658 Congress St

Department Reviews

Storage Room

PROPOSED STORAGE ROOM
658 CONGRESS STREET
PORTLAND, MAINE
PARTIAL FIRST FLOOR PLAN

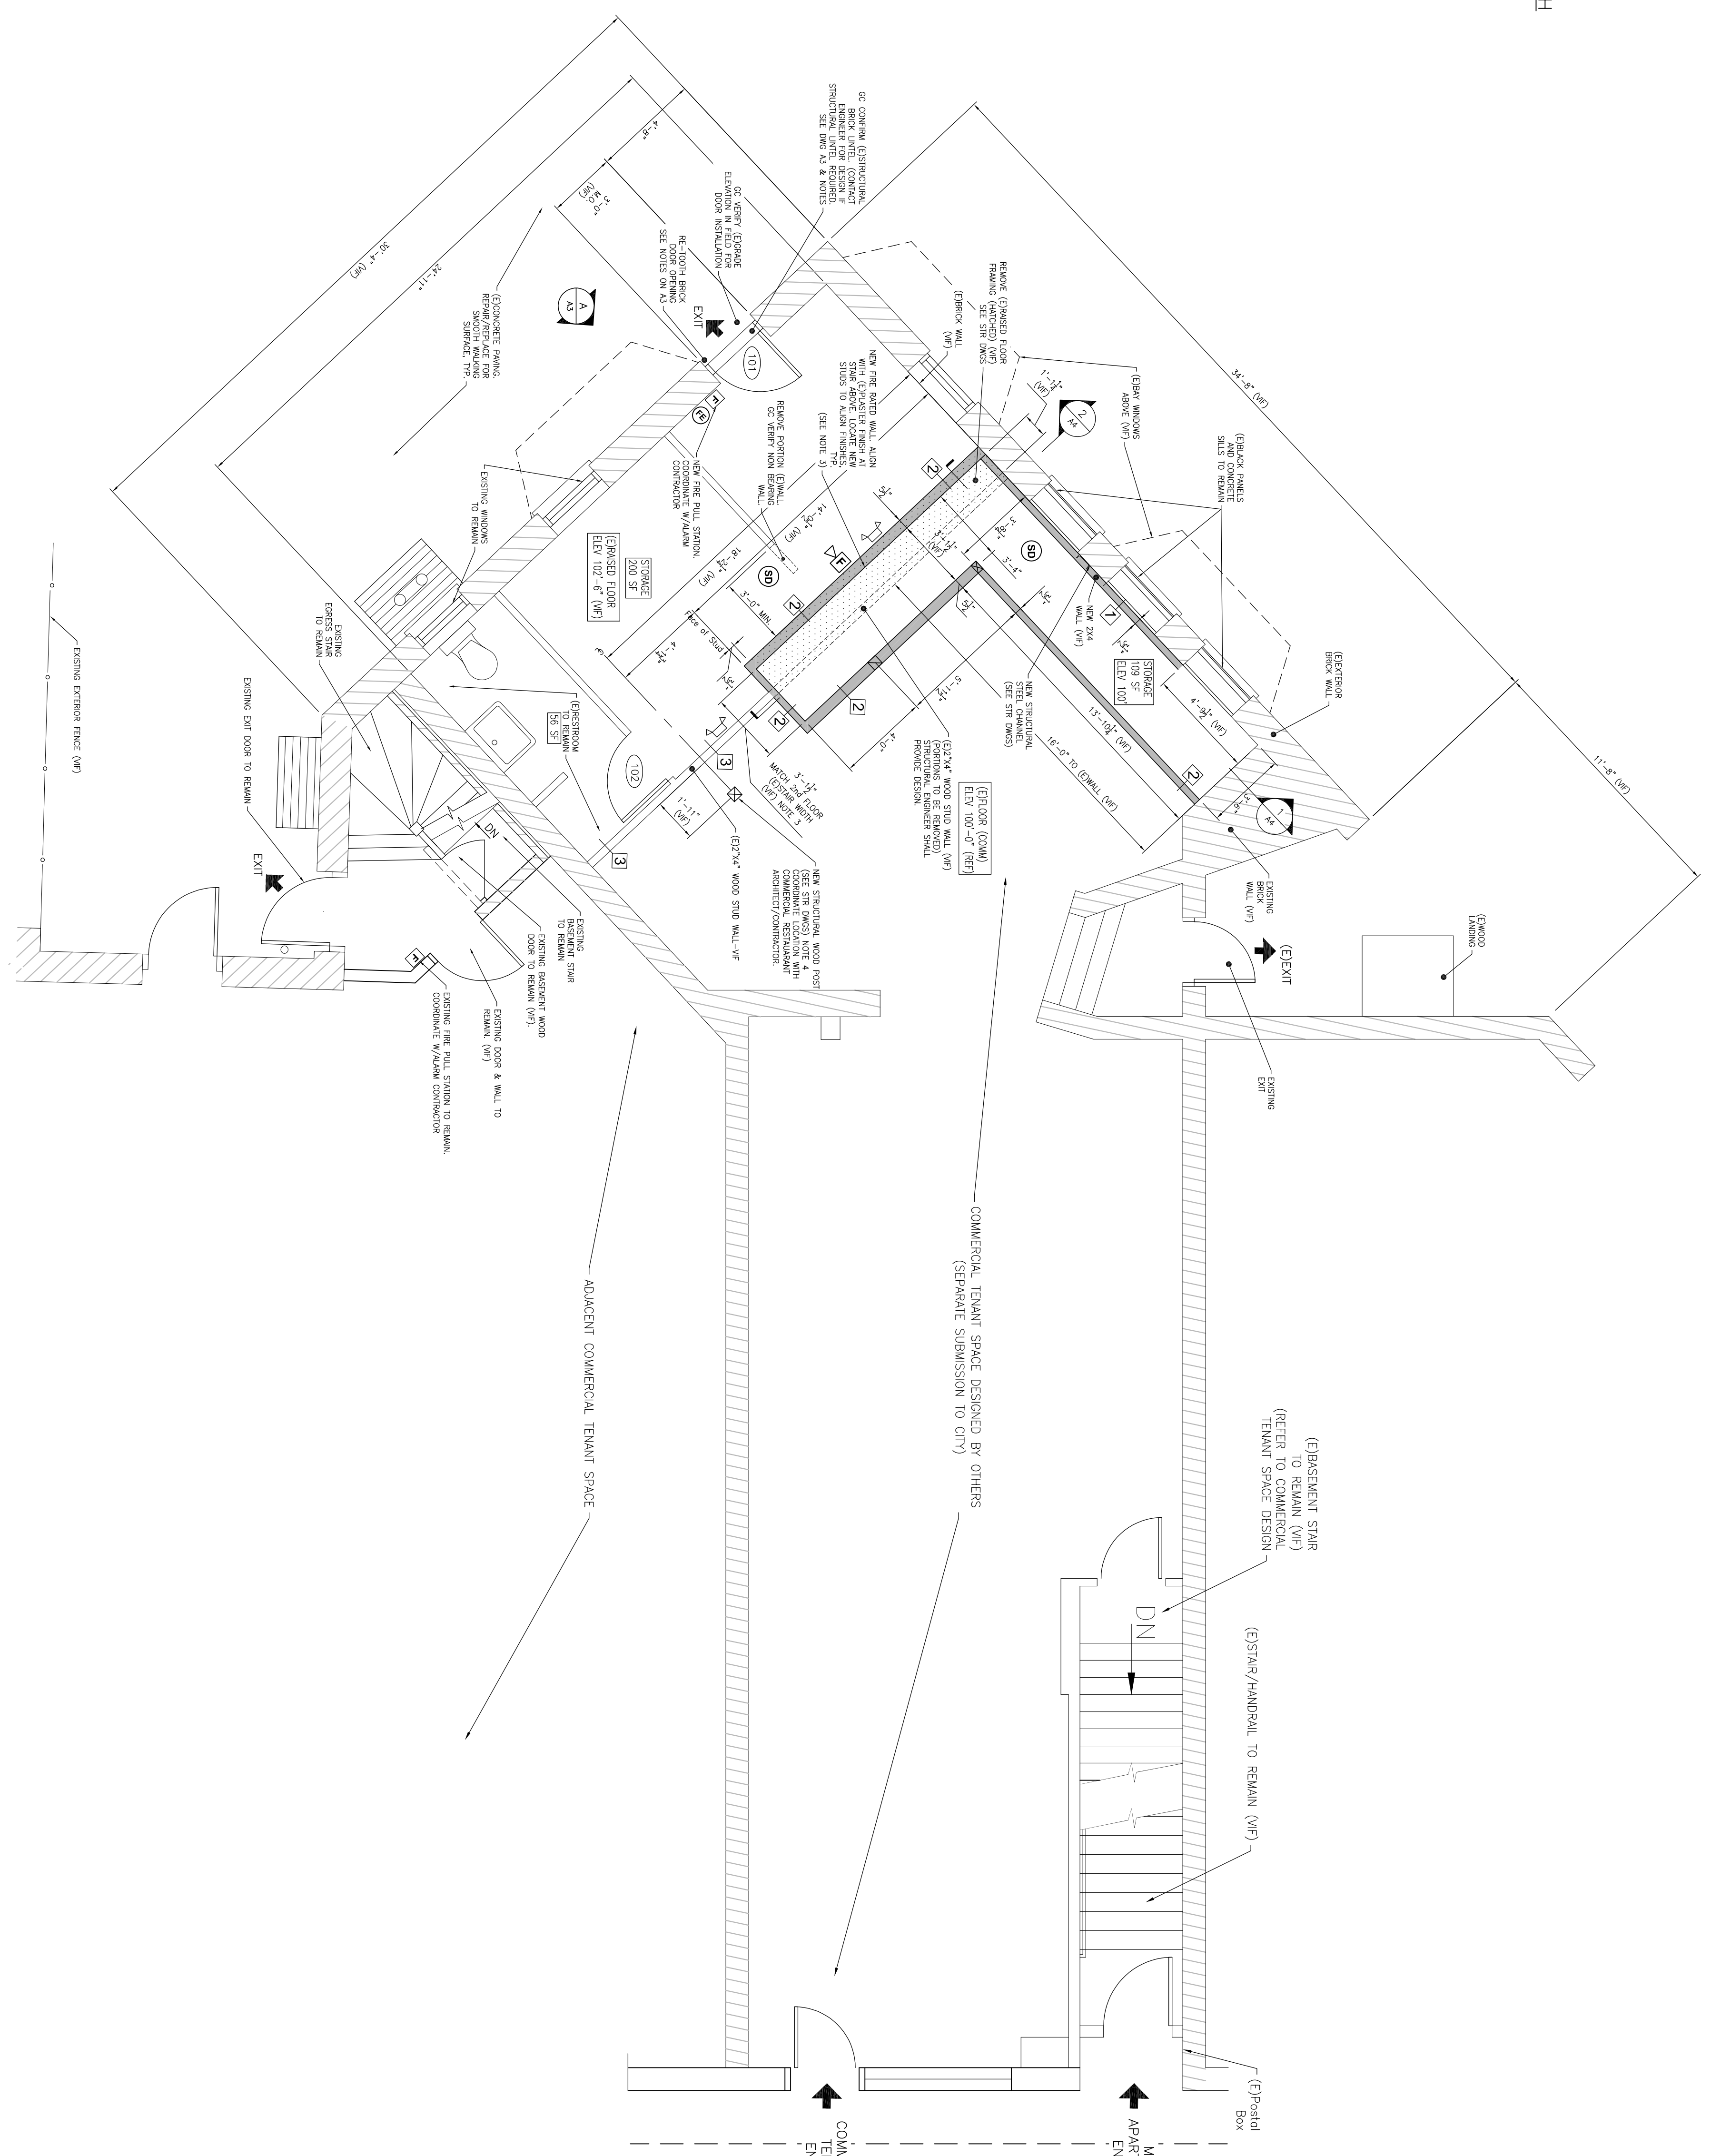
Dept	Comment Date	Comment
Zoning	11/15/2017	Emailed Geoffrey Rice. Need to know: 1. Plan A2 references a proposed storage room. What is going to be stored there and what part of the building is it going to be associated with? 2. How many dwelling units are in the building and can you tell me how many are on each floor?

- ① PROPOSED STORAGE is for owner, not Tenants. items such as DOORS, AND OFFICE materials.
- ② There ARE 21 apartments in Bldg. 7 Apartments per floor.
